Response to Planning Application

From: Arun District Council Greenspace

Application ref: A/102/22/PL

Description: 1 No new dwelling. This application is a Departure from the Development Plan and is in CIL Zone 3 and is CIL Liable as new dwelling.

SITE LAYOUT PLAN AS PROPOSED

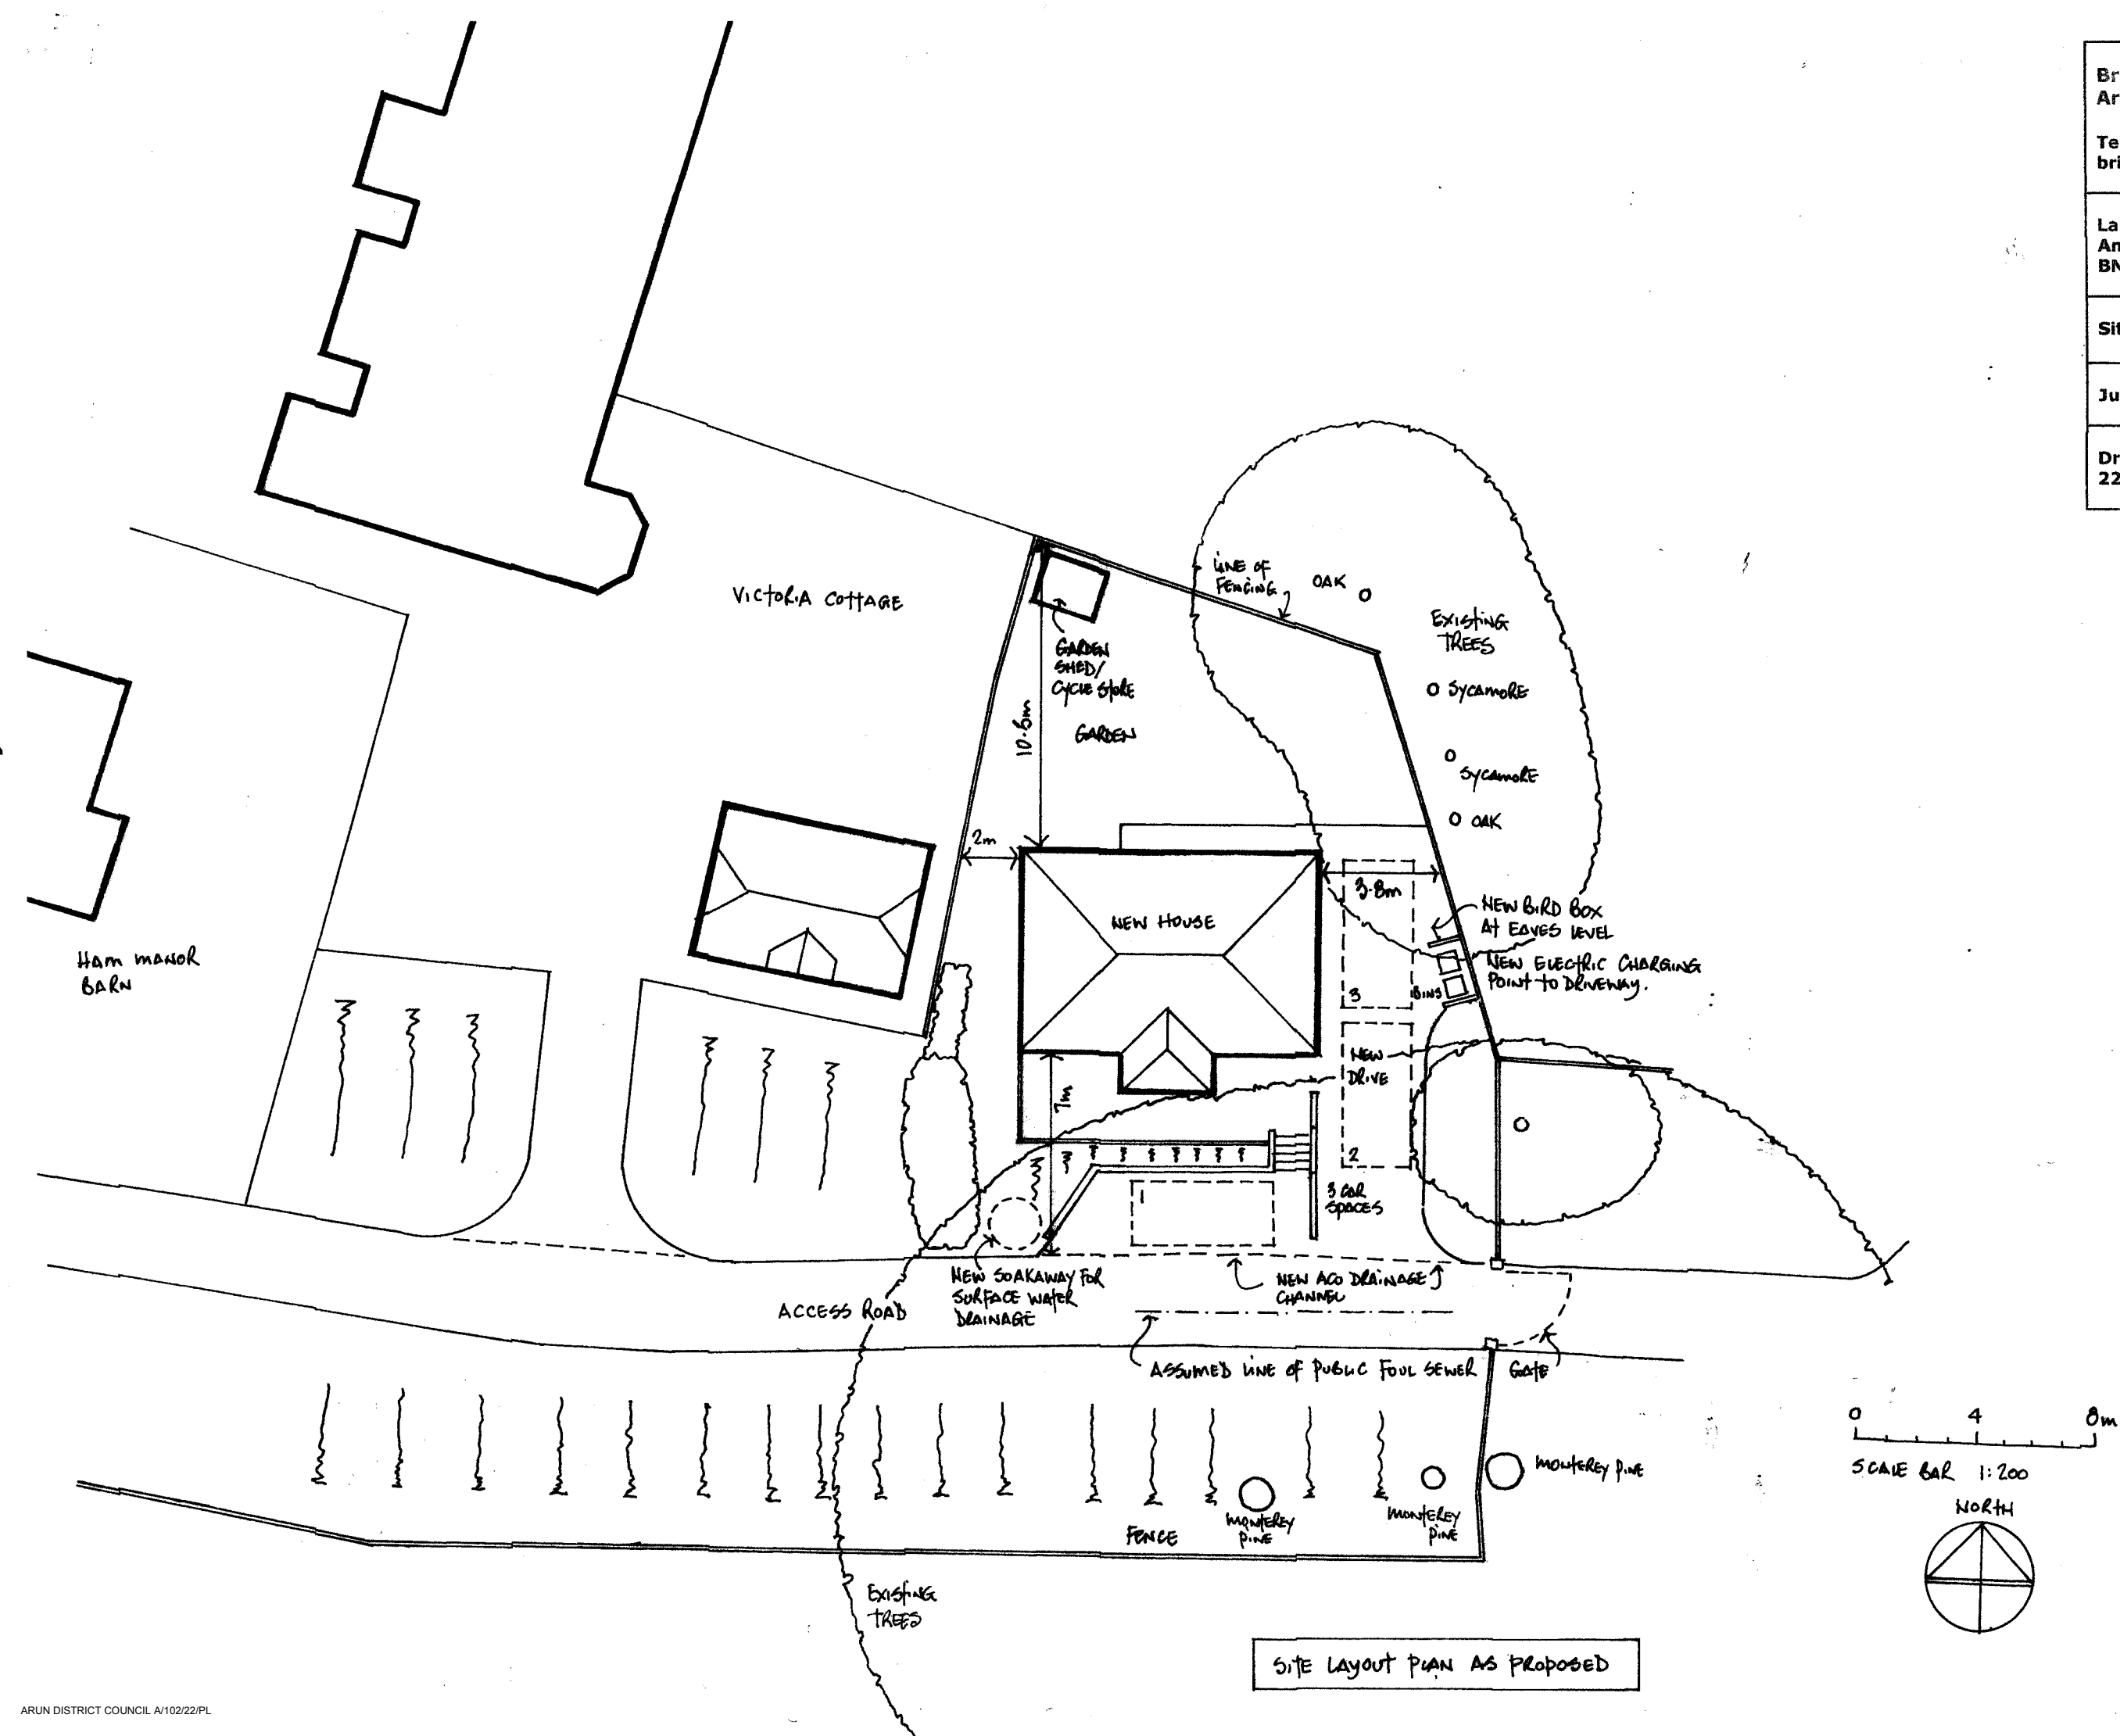
It is unclear from the submission the extent of clearance works and potential vegetation removal works required to undertake the proposed build.

The NPPF para 124/127 relate to good design principles which equally apply to small infill and replacement development. The indicative site layouts has shown the adjacent offsite trees but no indication has been made re new or screen landscaping. These details would require submission in the form of a detailed planting plan and specification detailing species choice, actual plant quantities, planting densities and size at time of planting. Detail should also be provided regarding existing trees and boundary planting.

A full landscape scheme will need to be submitted for approval, or conditioned as part of any approval; detailing species choice, position, densities and size at time of planting. This should be plotted in plan and list form and in relation to the trees and vegetation to be retained so that a clear picture of the proposals can be seen. These details are required to ensure that appropriate mitigation is provided, maintaining and uncompromising the setting and ensuring that the proposals fit within the area of neighbouring properties. These will need to incorporate screening as required, adding to and enhancing the setting.
